The Old Post Office,
Main Street,
Sibford Gower,
Banbury,
Oxfordshire, OX15 5RT.
30th. January 2020.

Re: 19/02700/F Development at Mawles Farm, Sibford Gower.

**Drawing title**  
Existing & Proposed Street Elevations  
Sheet 2 of 2

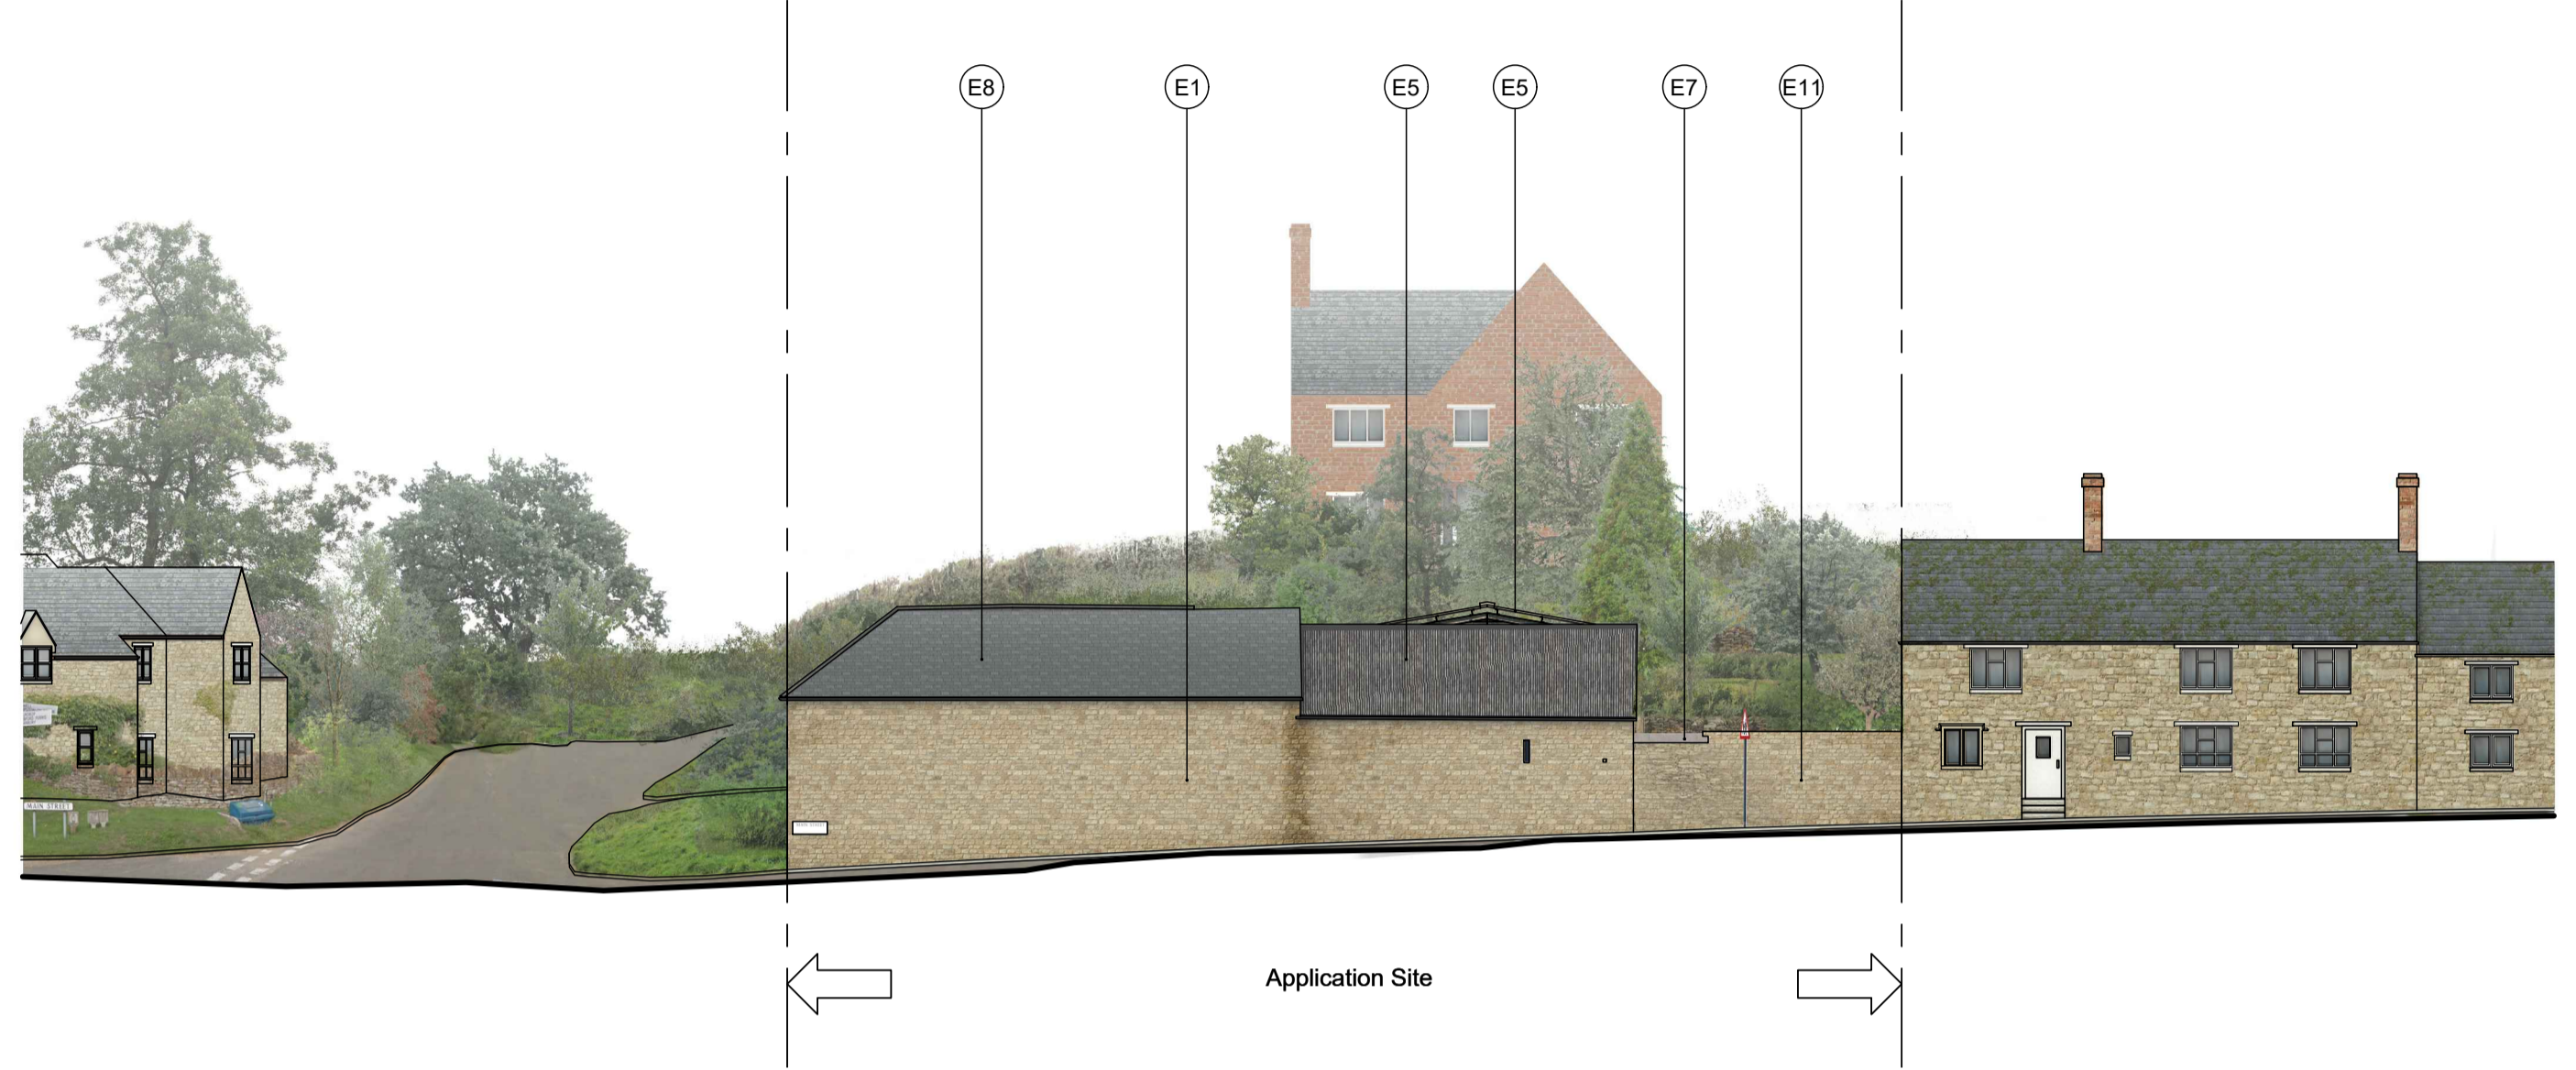
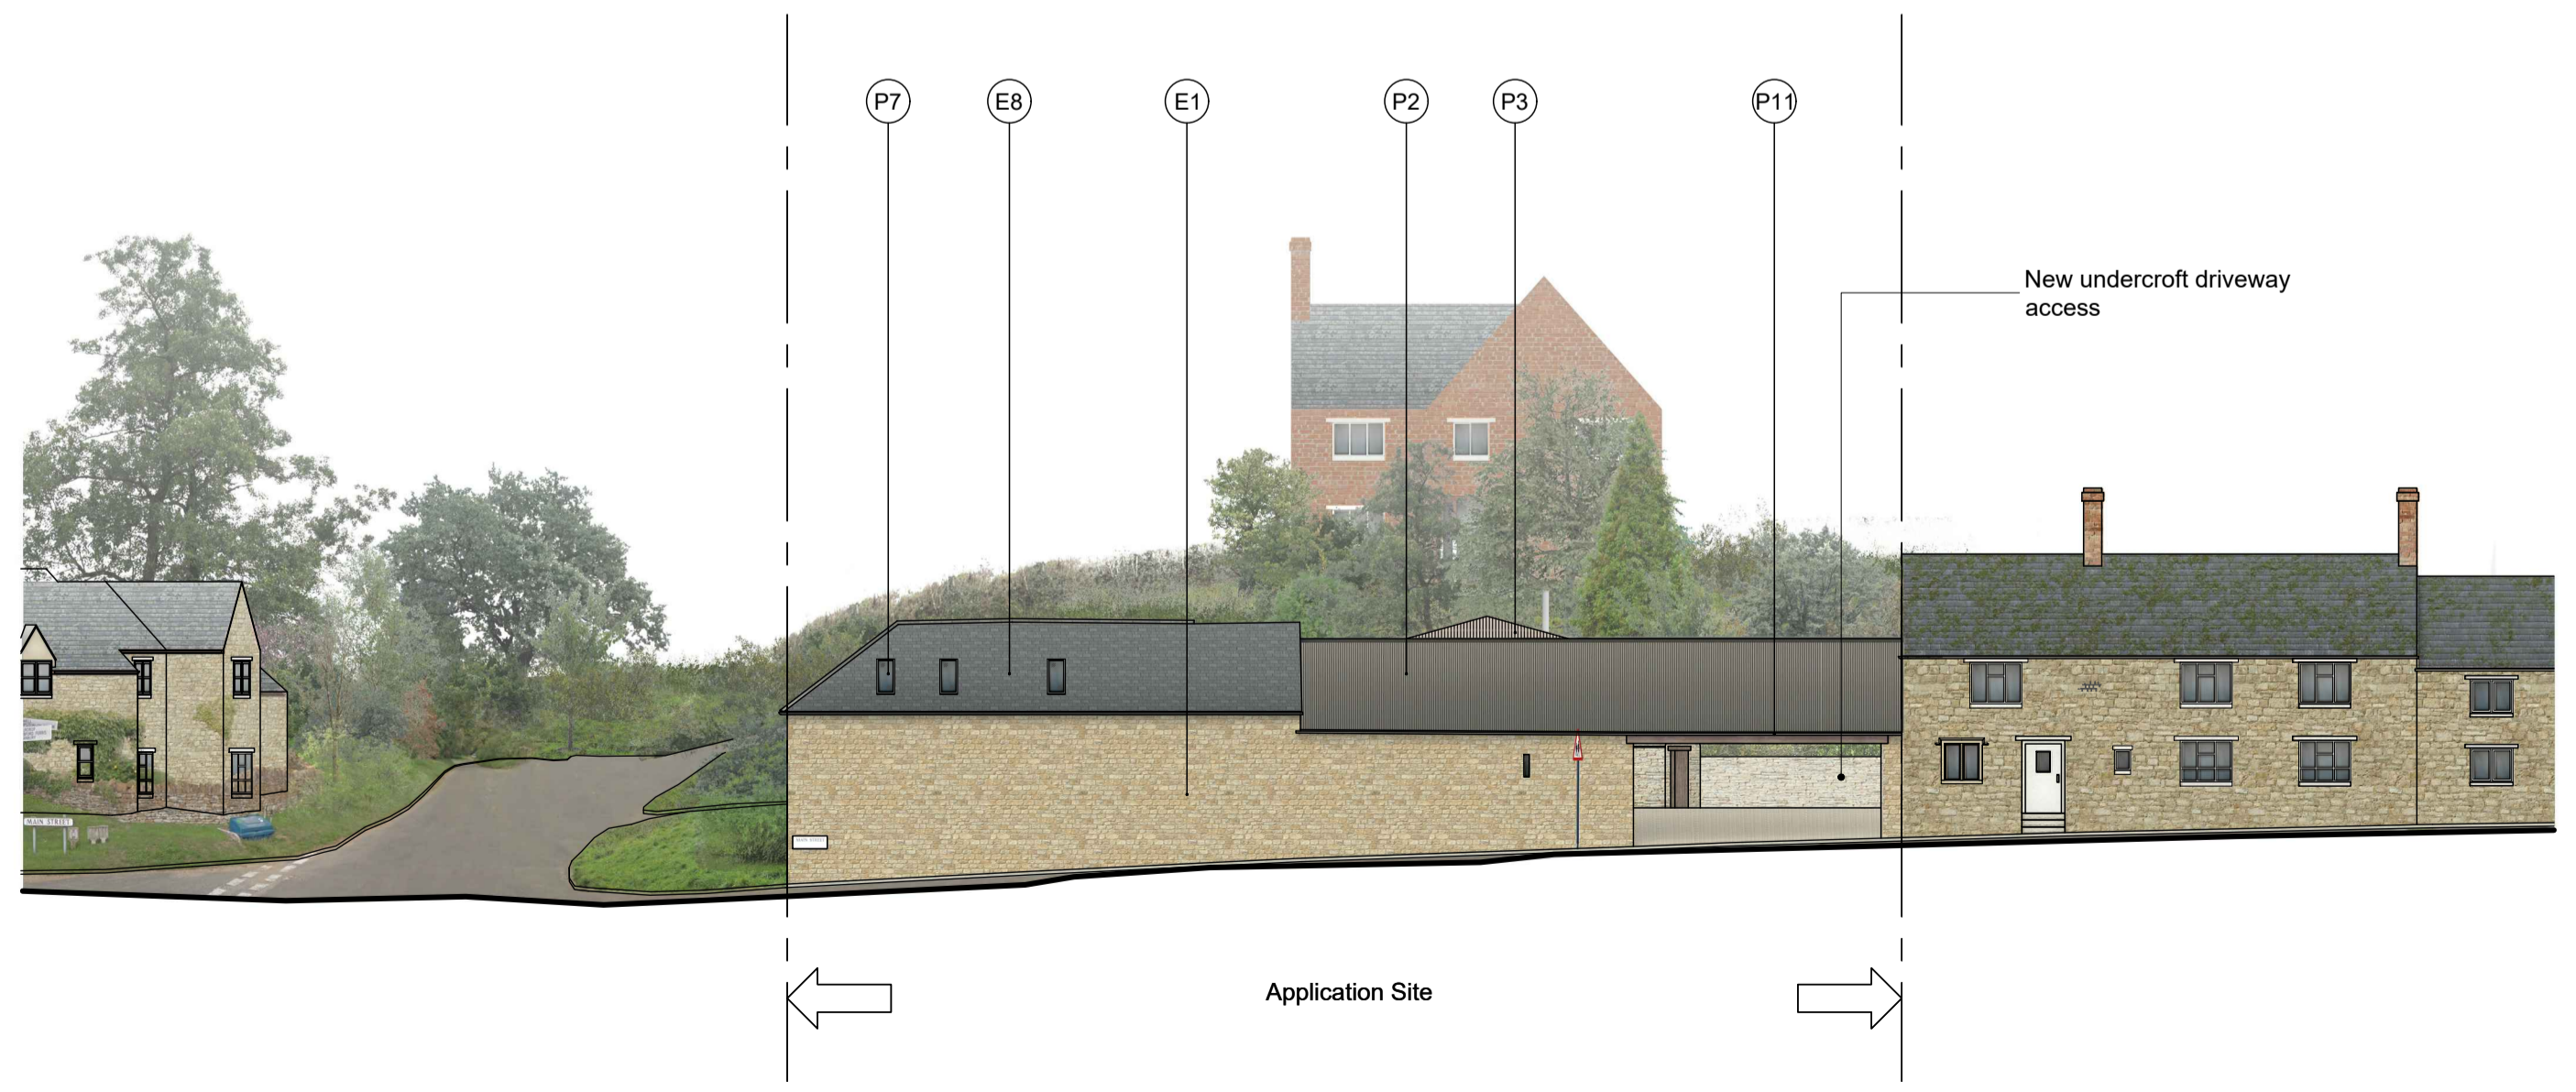
The proposed driveway onto Main Street should not be granted because: There is inadequate visibility due to the barn walls, which are built at the edge of a narrow pavement. Infant and junior aged school children walk by, to attend Sibford Gower Endowed Primary School.

The proposed building to replace the open shed/barn will be seen from the road. This is a conservation area and buildings should be sympathetically designed to suit the surrounding area. It looks like an industrial building for intensive farming or industrial use. It is flat, ugly and characterless. It should be softened in design and have more of an open barn character.

Most old buildings in the village have slate roofs. Tin roofs will look cheap and not enhance the building.
